August 30, 2016

## **Addition to Bayside Bowl Portland, Maine**

### **Plan Revision Narrative**

1 ASK-03 - RELOCATED PROSHOP / ARCADE
 1/4" = 1'-0"

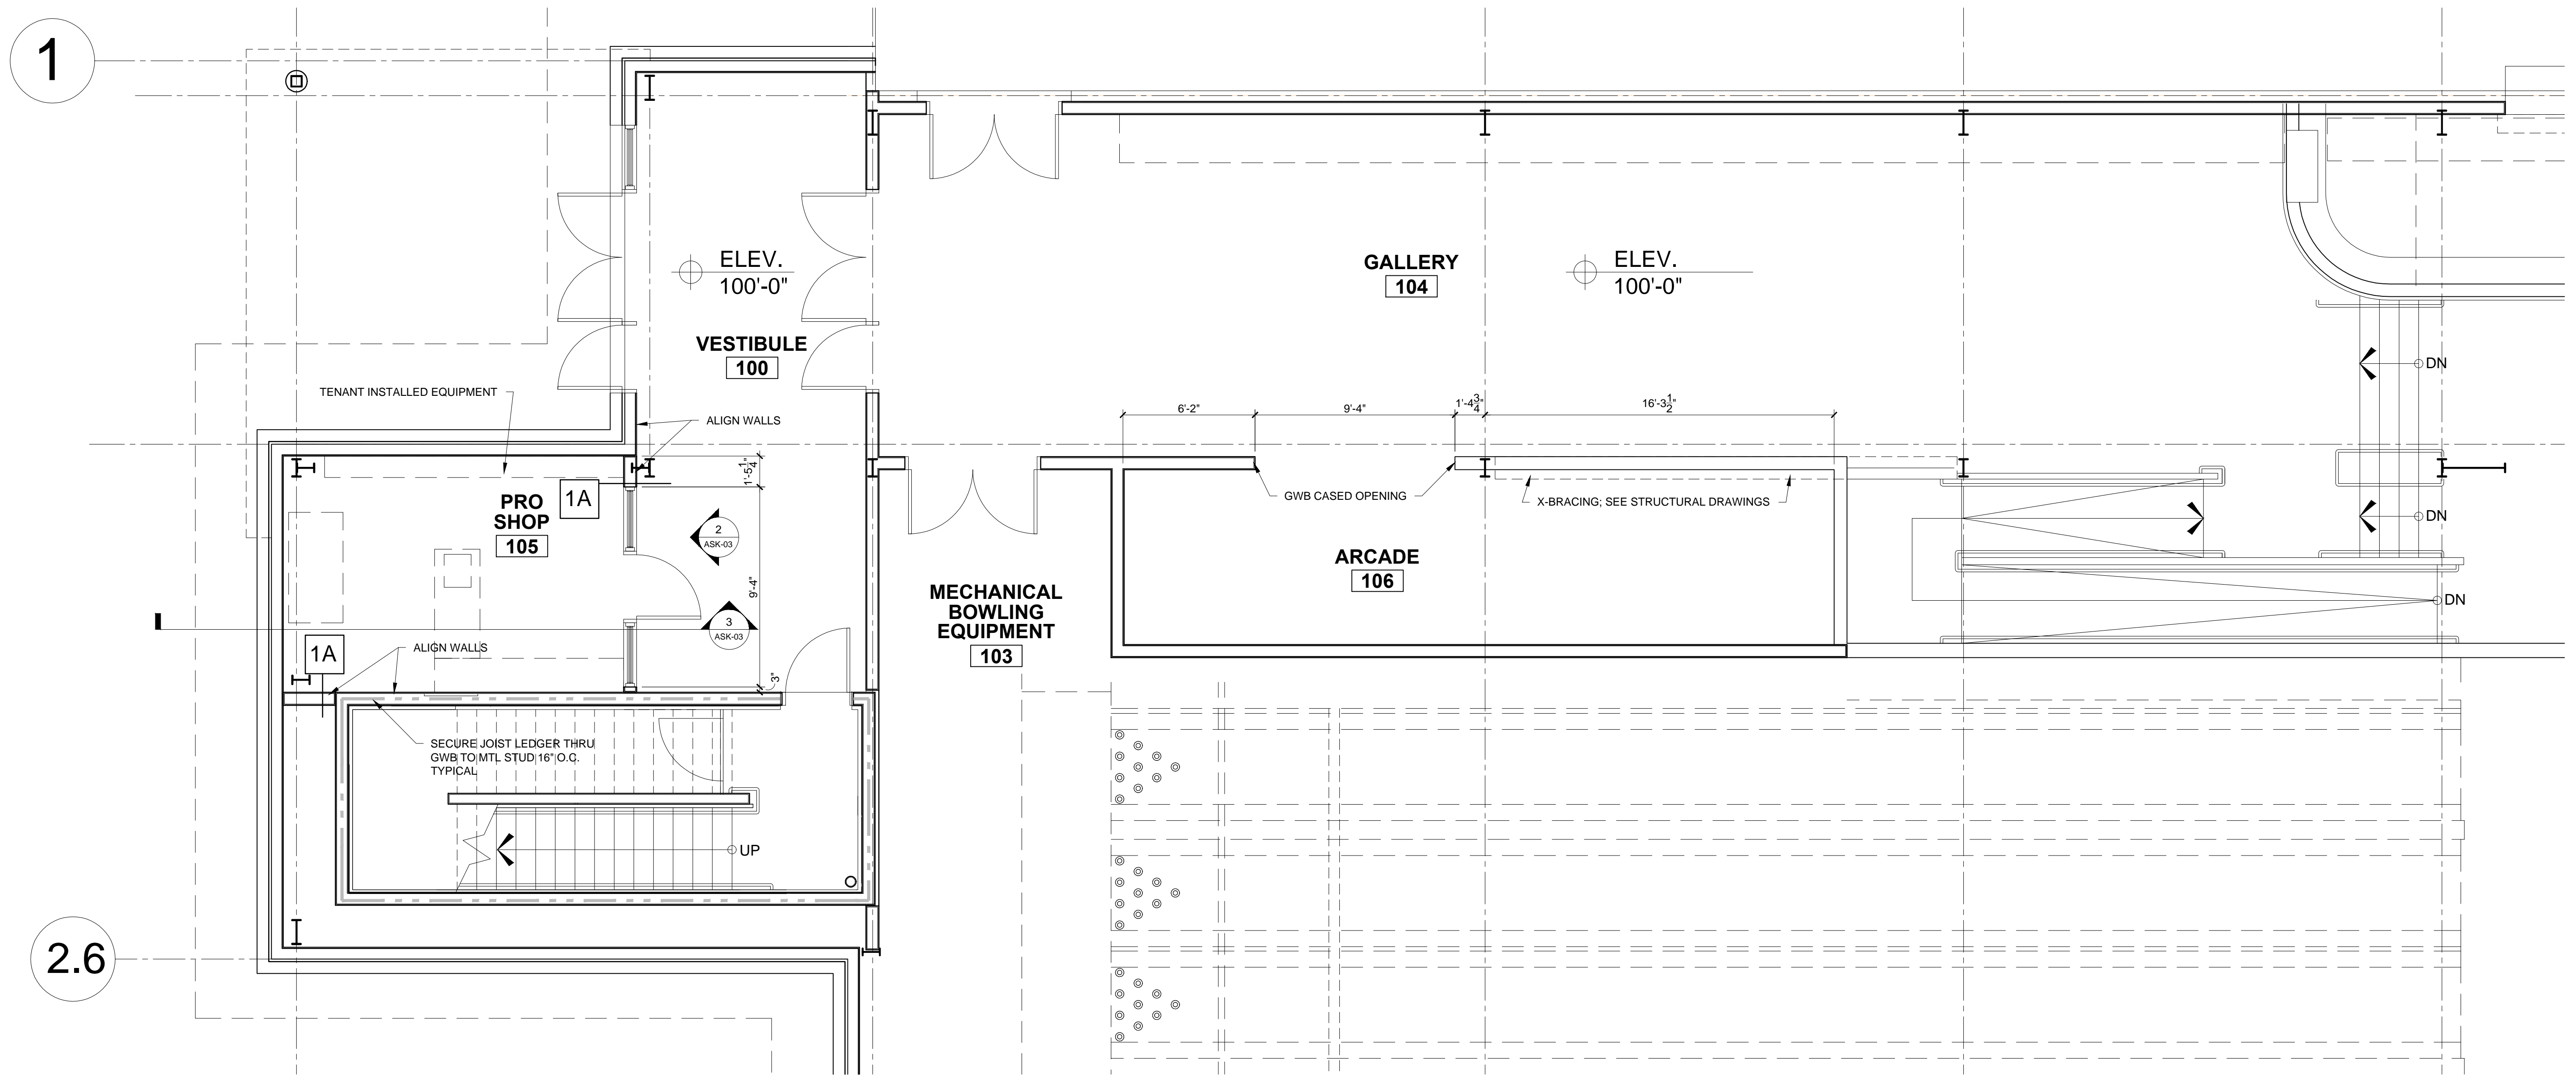
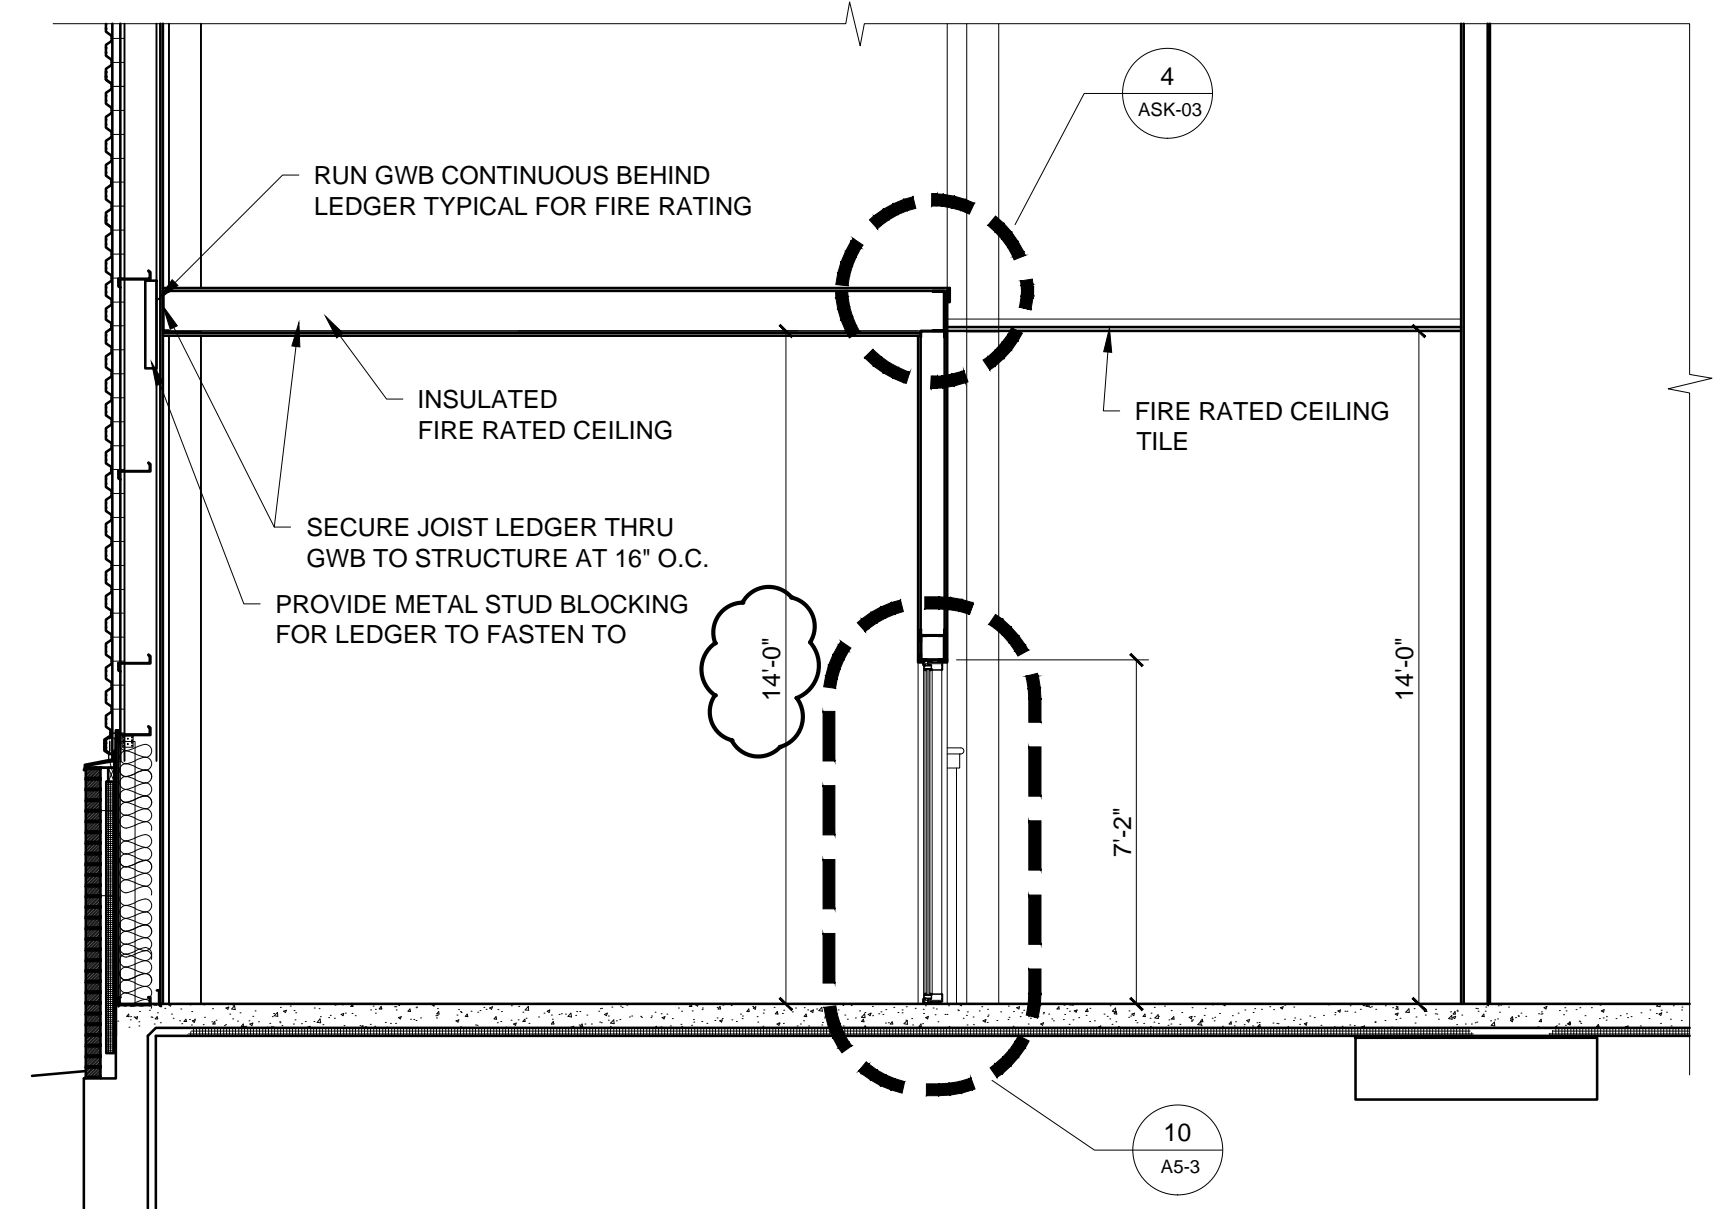
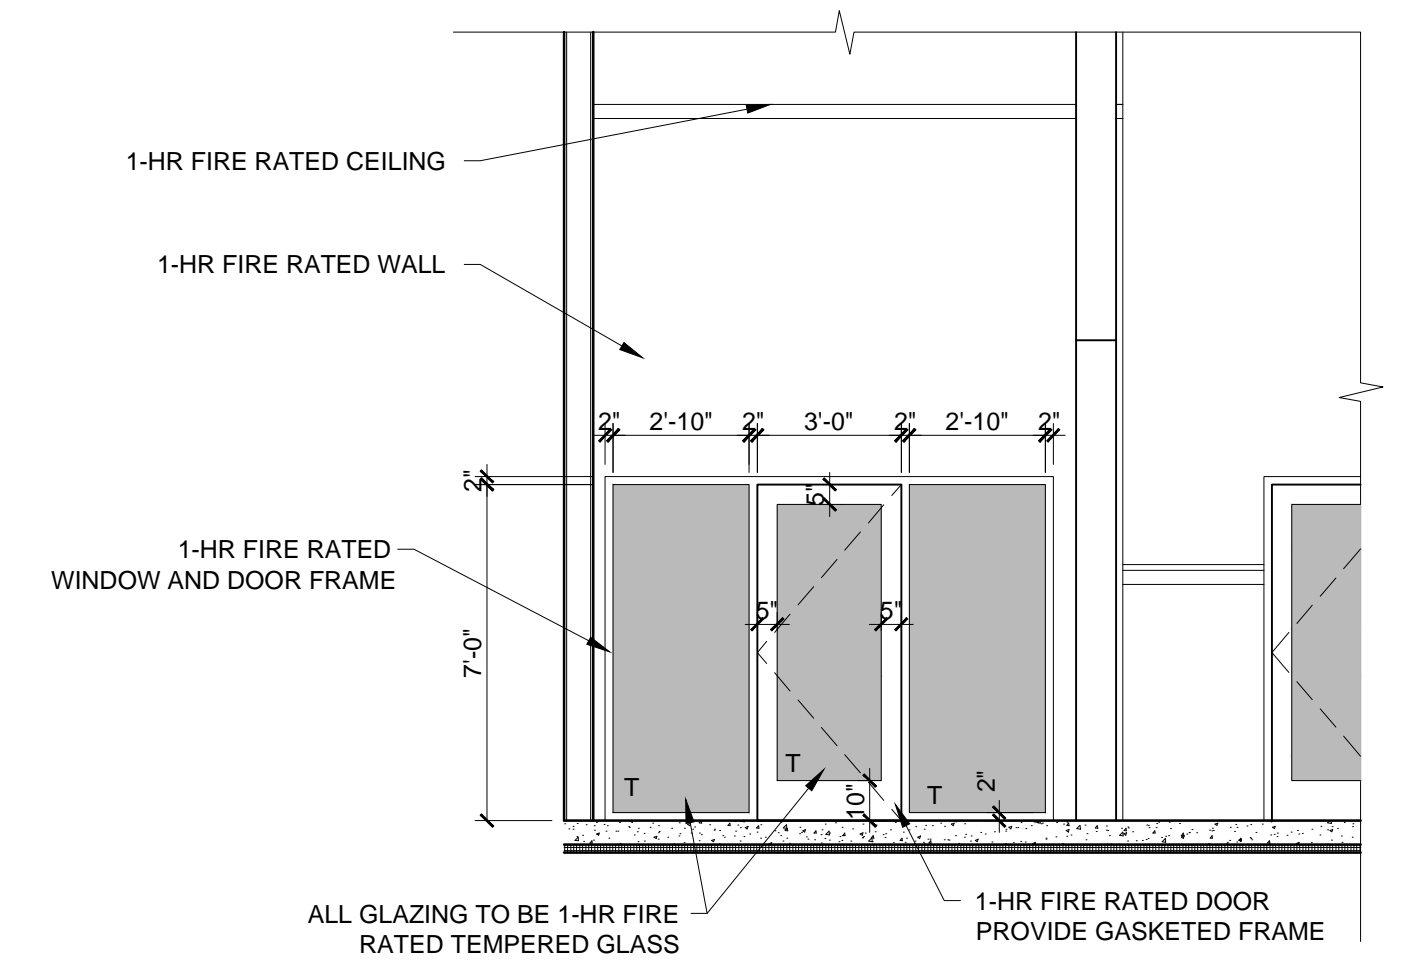
- 1.) Drawing A1-1 and ASK-03, we relocated the Pro Shop and reconfigured the coatroom into an area for a small arcade
- 2.) Drawing A1-1 and ASK-06, we relocated the first floor bathrooms toward Stair 114 and raised a section of the floor at the previous bathroom location to provide a raised seating area.

ASK-05

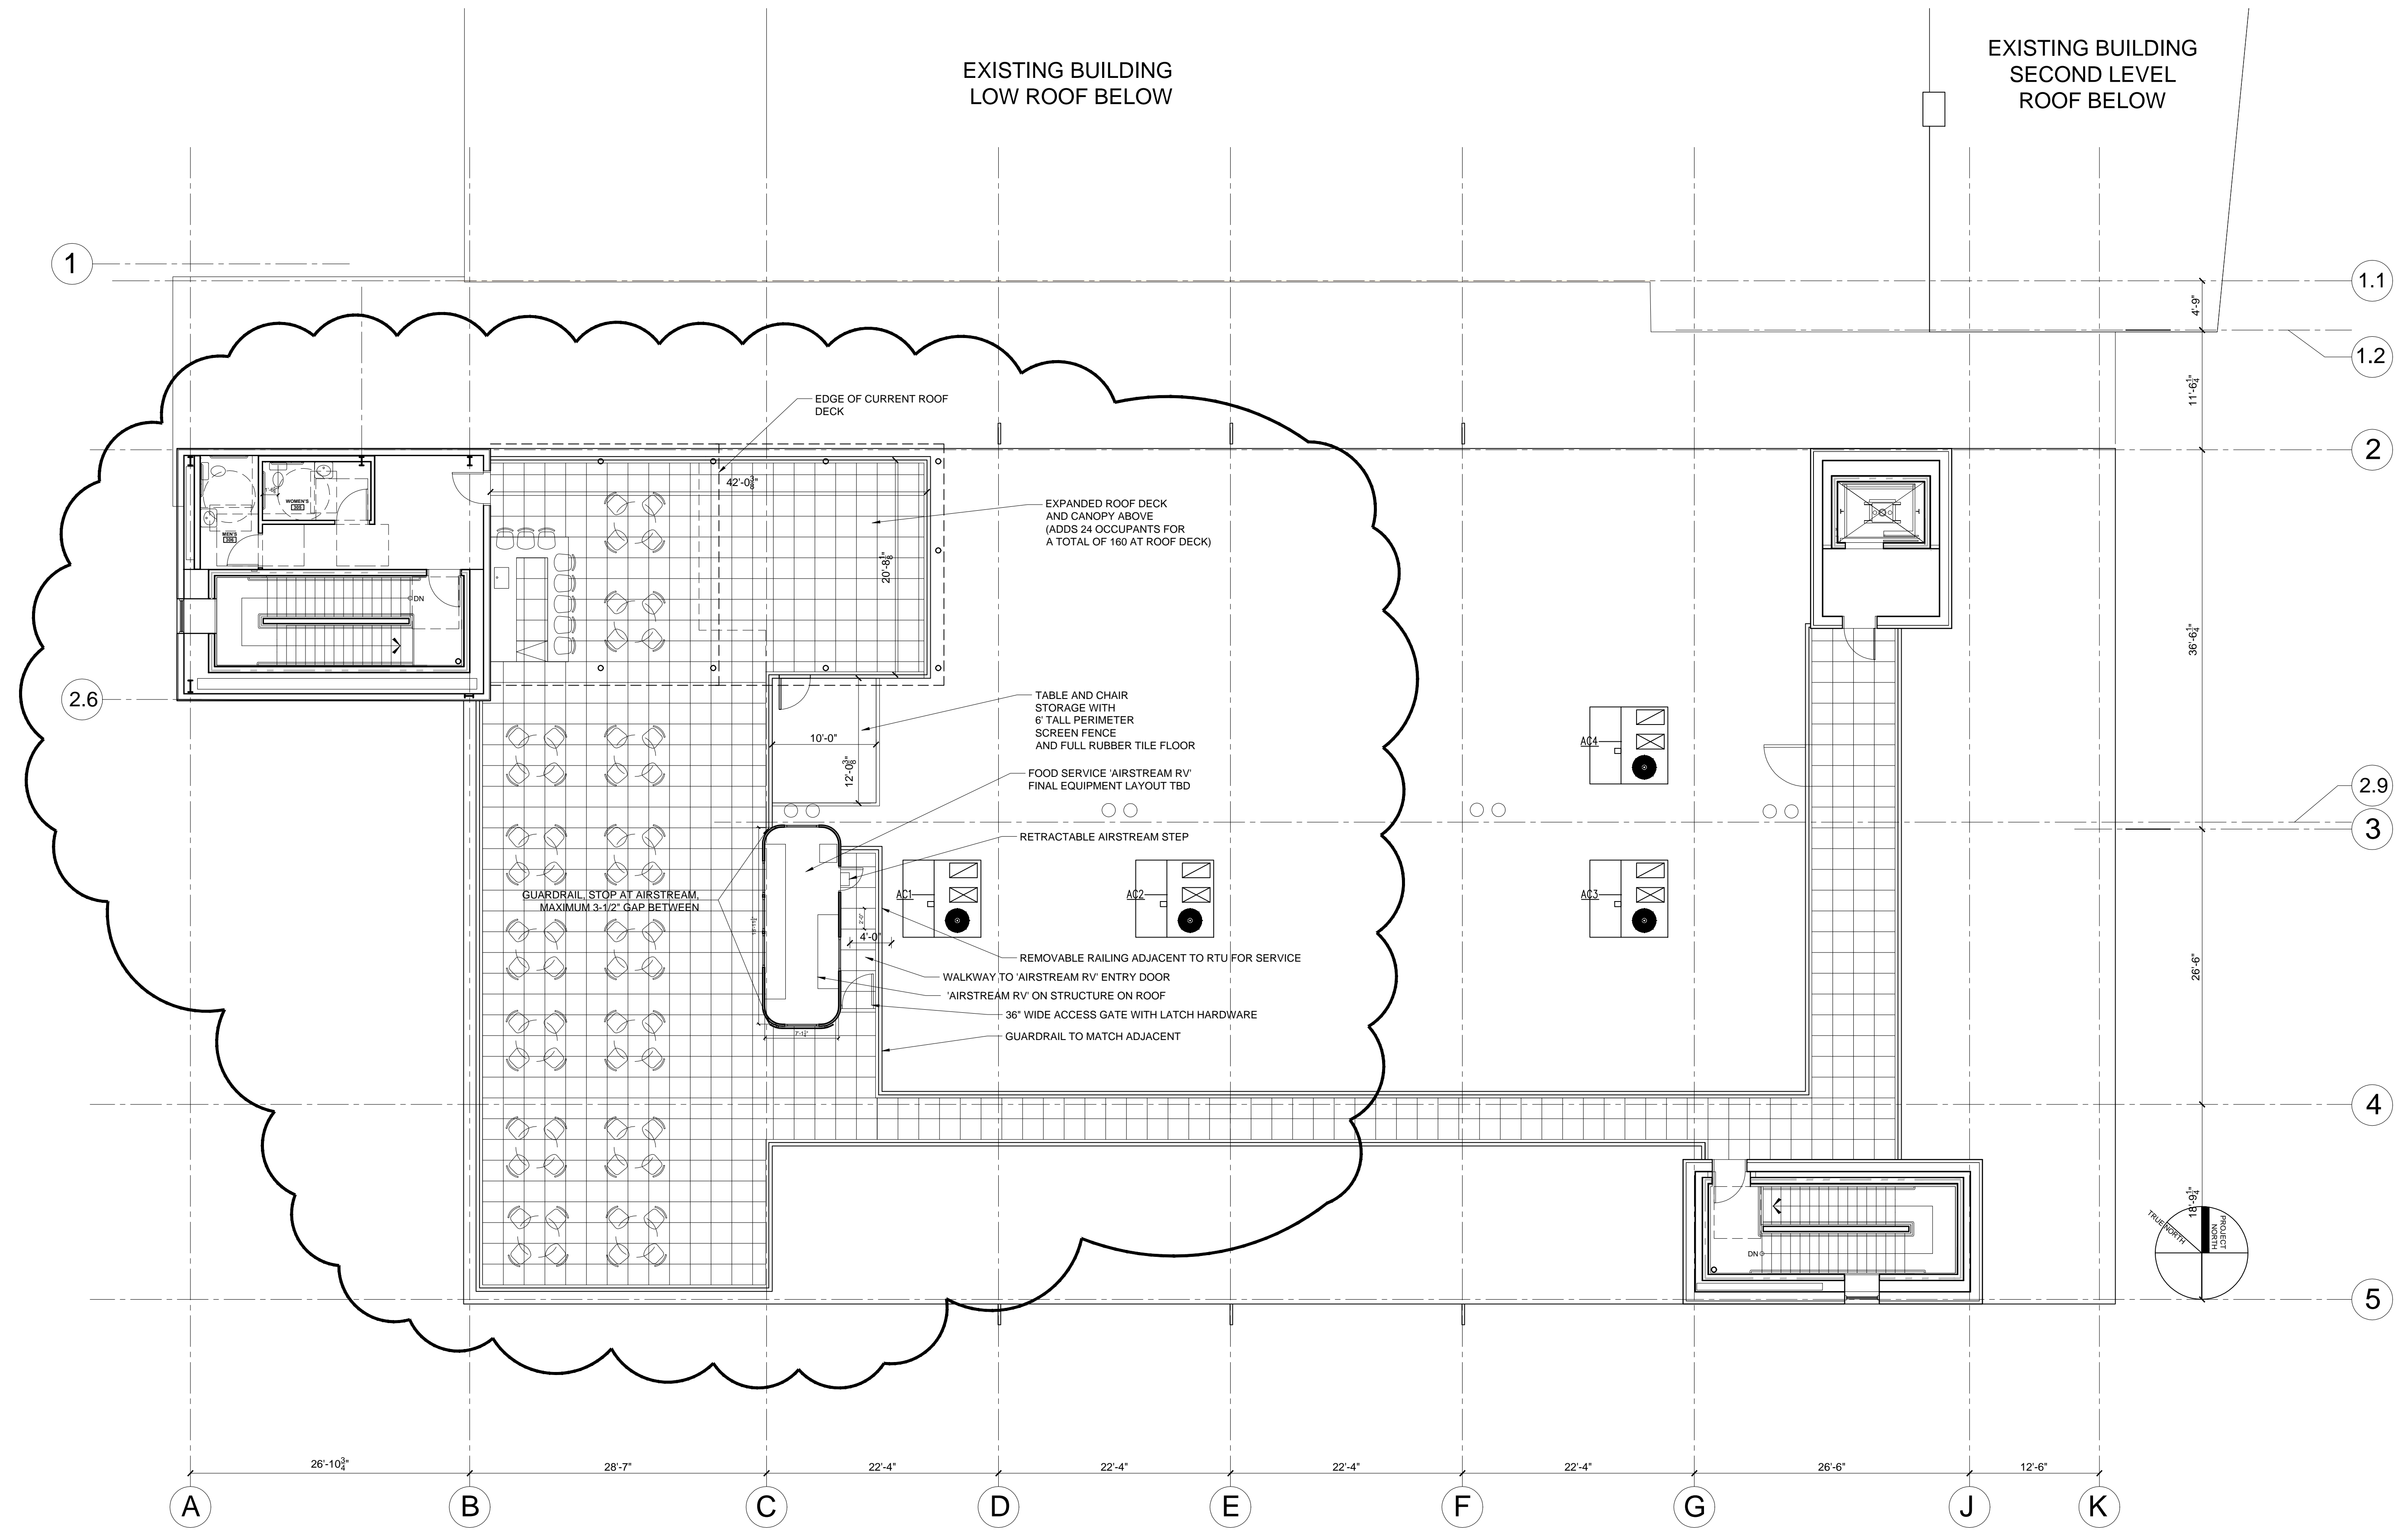
- 3.) Drawing A1-1, we modified the shape of Bar 113 slightly to accommodate the new bathroom location
- 4.) Drawings A2-1, A2-2, A2-3, and ASK-05, we revised the roof top deck size and shape by extending the exterior canopy that is attached to the egress Stair by 21' in length. The larger deck increased the occupant load at the roof level by 24, for a total of 160 occupants.

- 5.) Drawing ASK-05 and ASK-05A, we have added an 'Airstream RV' on the roof, this will be modified so food can be served from it to the patrons on the roof deck. We are finalizing the equipment layout within the RV and will submit that additional information in the coming weeks.

- 6.) Drawing ASK-05 and ASK-02, We have added two Accessible restrooms at the roof top level adjacent to the egress stair.
